Application by Light Valley Solar Limited for an order granting development consent for the proposed Light Valley Solar project.

Issue Specific Hearing 1 (ISH1) – Action points and Errata and clarifications

Date: Thursday 30 July 2026

Drawing Title
Figure 2.6
Solar Panels Concrete Feet or Other Non-ground Penetrative Techniques
Sheet Number 1 of 4

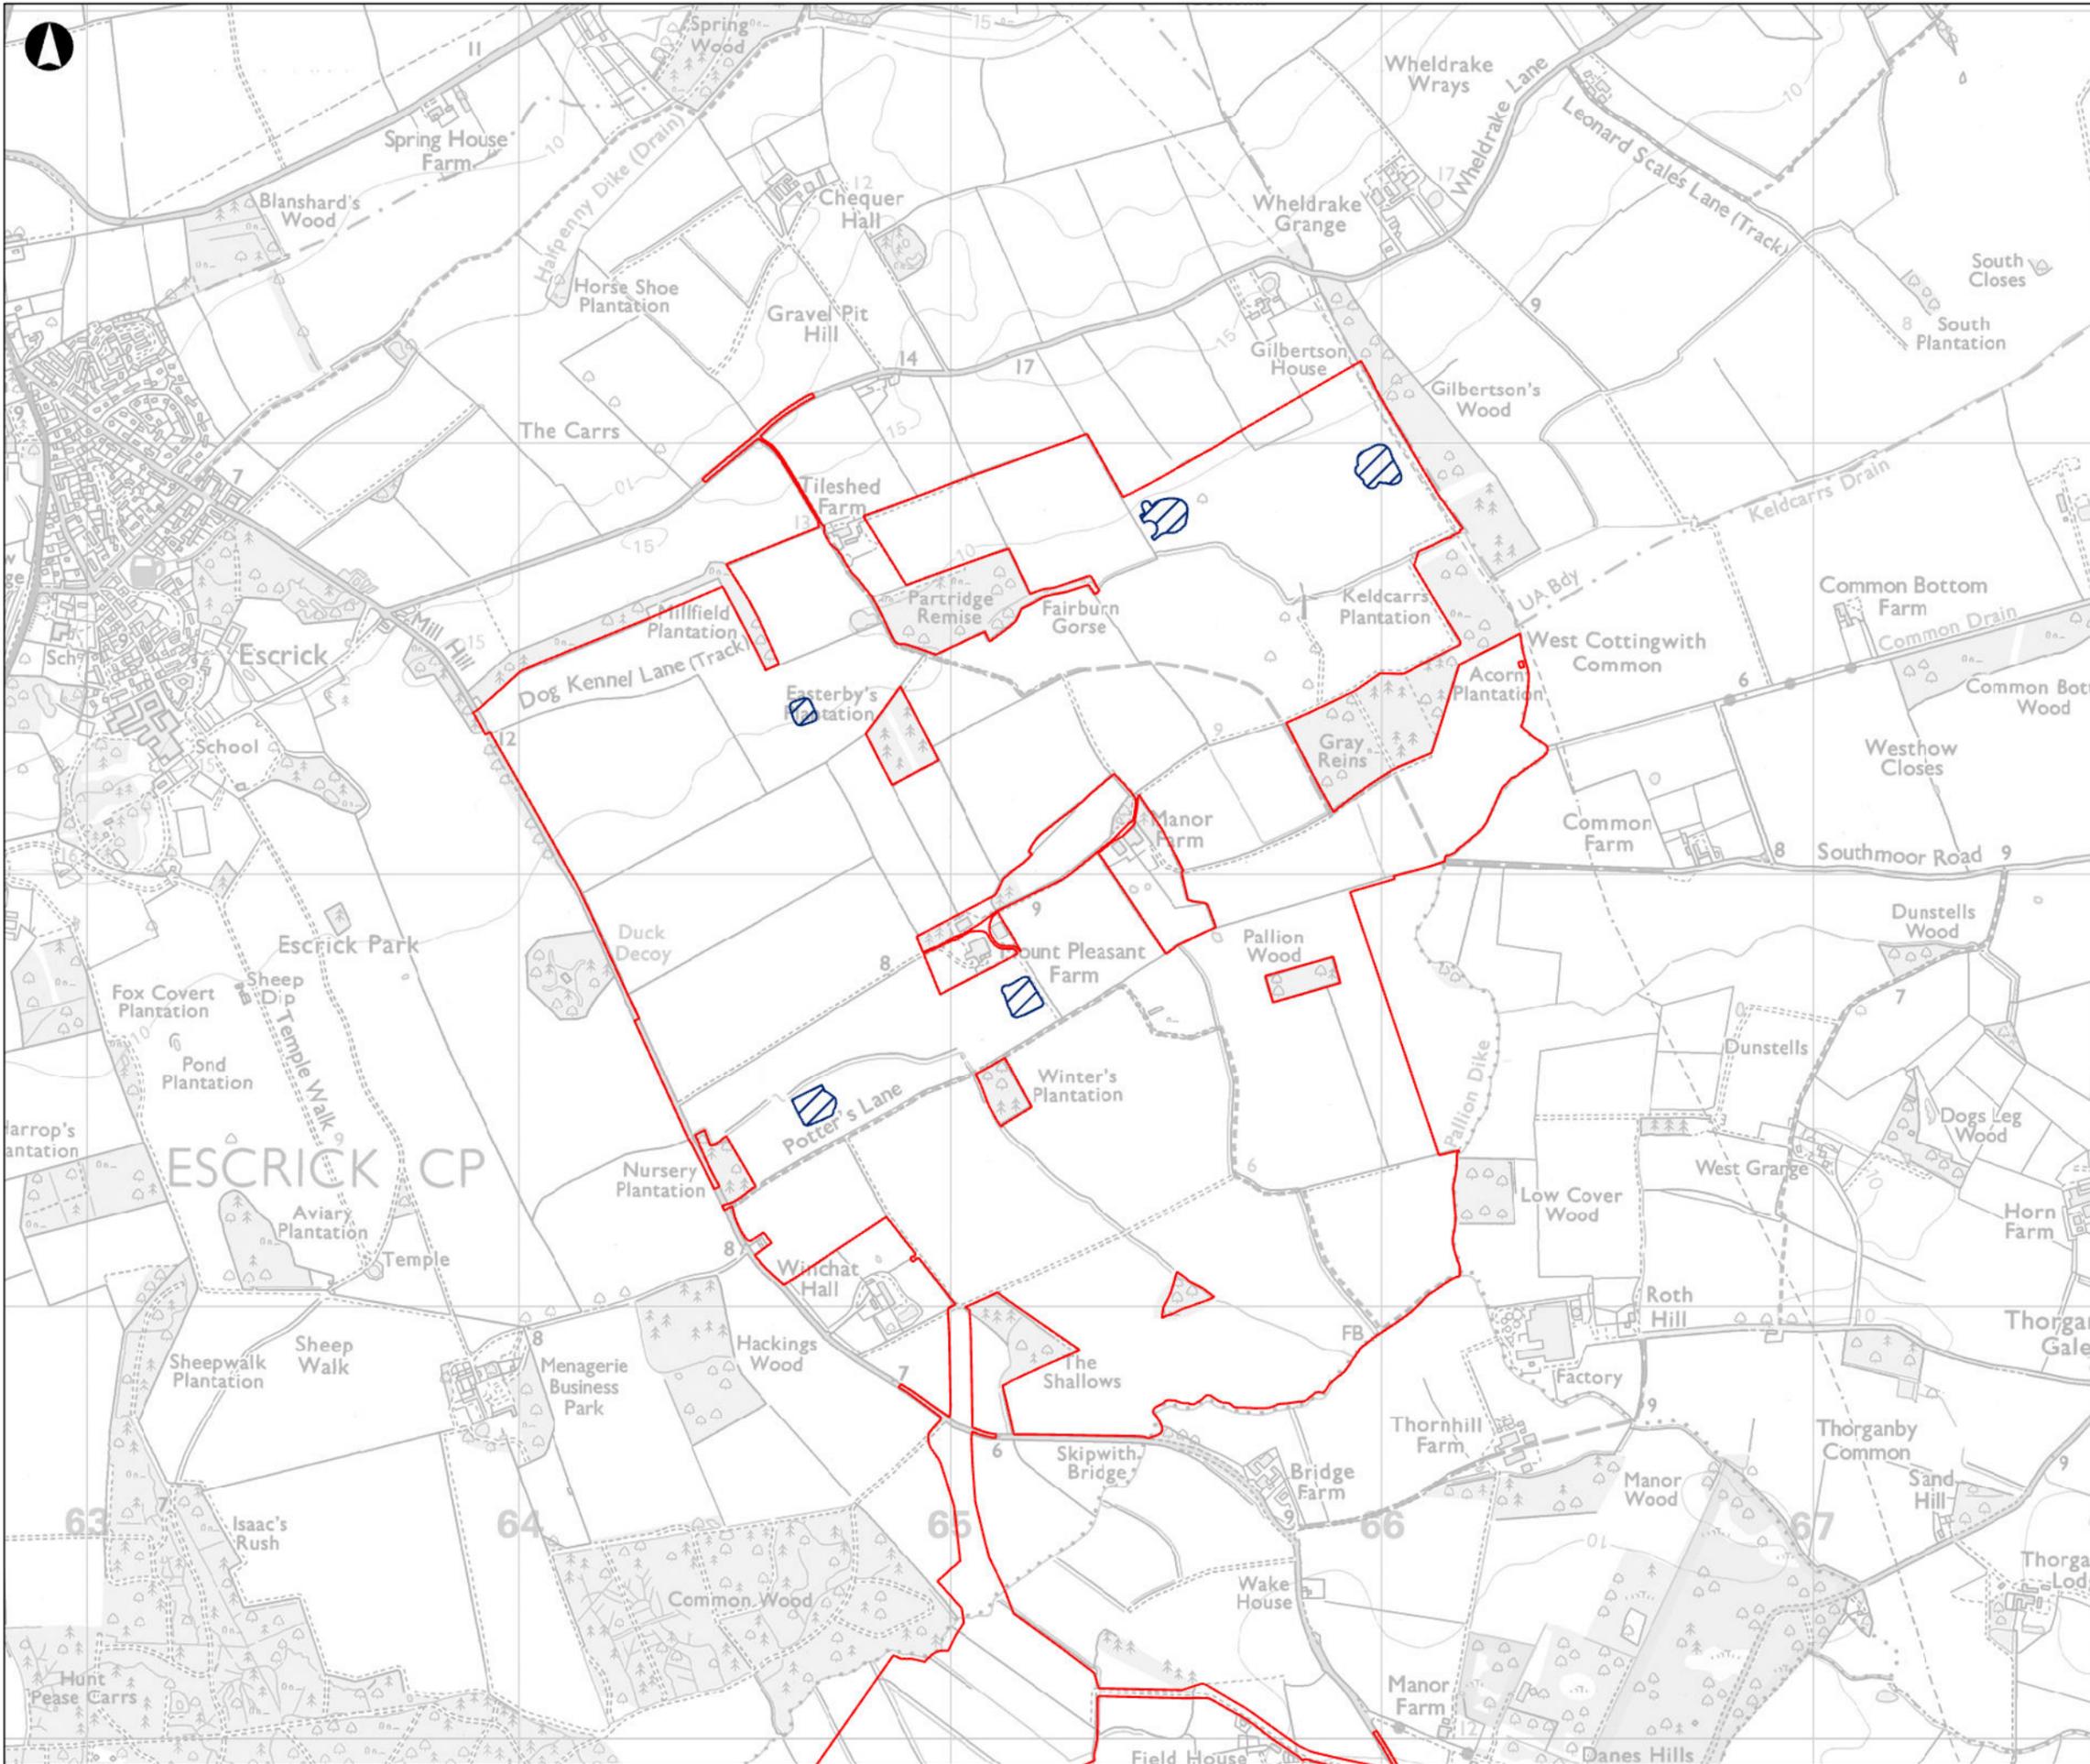
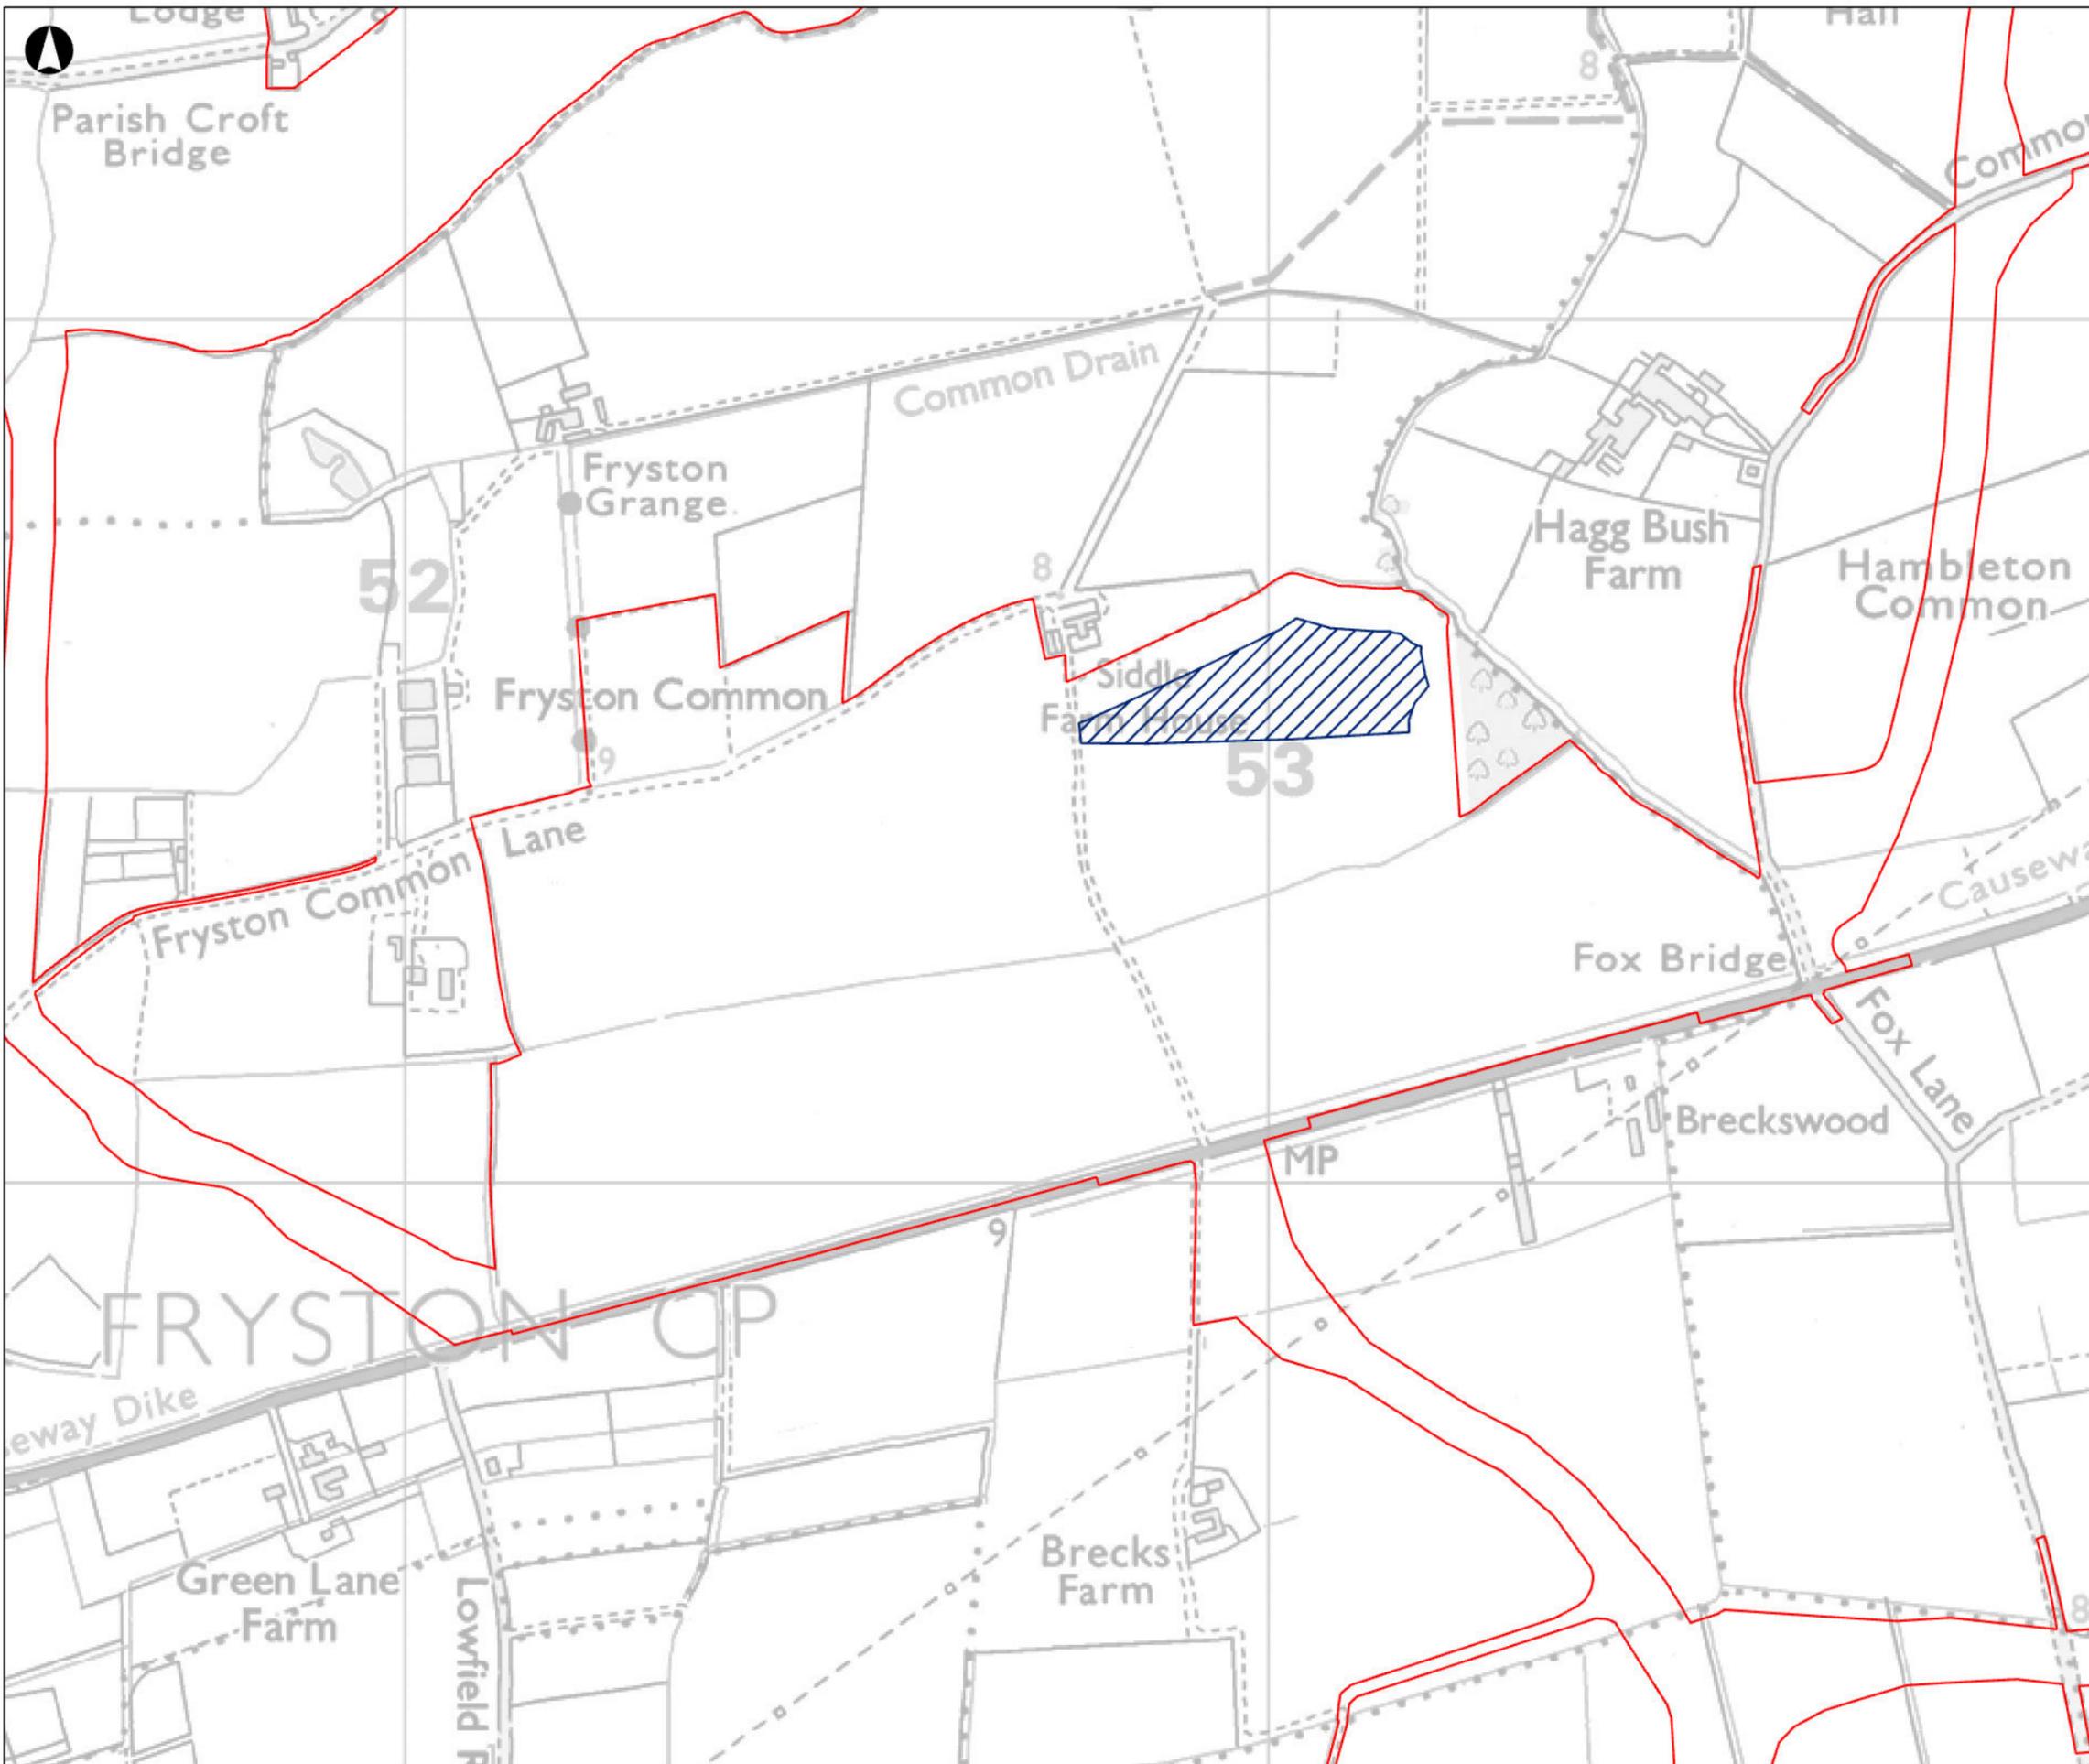
[APP-046]	ES chapter 8 and Figures 2.5 and 2.6	Paragraphs 8.8.3 and 8.8.5 of ES chapter 8 [APP-046] refer to the concrete feet locations or other non-ground penetrative techniques being shown on Figure 2.5 however this shows the Avoidance Areas [APP-062]. Is this reference correct, should it be Figure 2.6 instead which is entitled Solar Panels Concrete Feet or Other Non-Ground Penetrative Techniques [APP-063]. Please check and amend any references accordingly (this includes other documents and chapters).
[APP-190]	Non-technical summary, para 7.2.17	Paragraph 7.2.17 of the non-technical summary [APP-190] states that there is 495ha of best and most versatile agricultural land within proposed development and that approximately 17.5ha would be required for the permanent elements involving soil sealing. These figures differ to those cited elsewhere within the ES (i.e. paragraph 5.9.19 of ES chapter 5 [APP-043]) which states figures of 486ha of land and 19.1ha respectively.
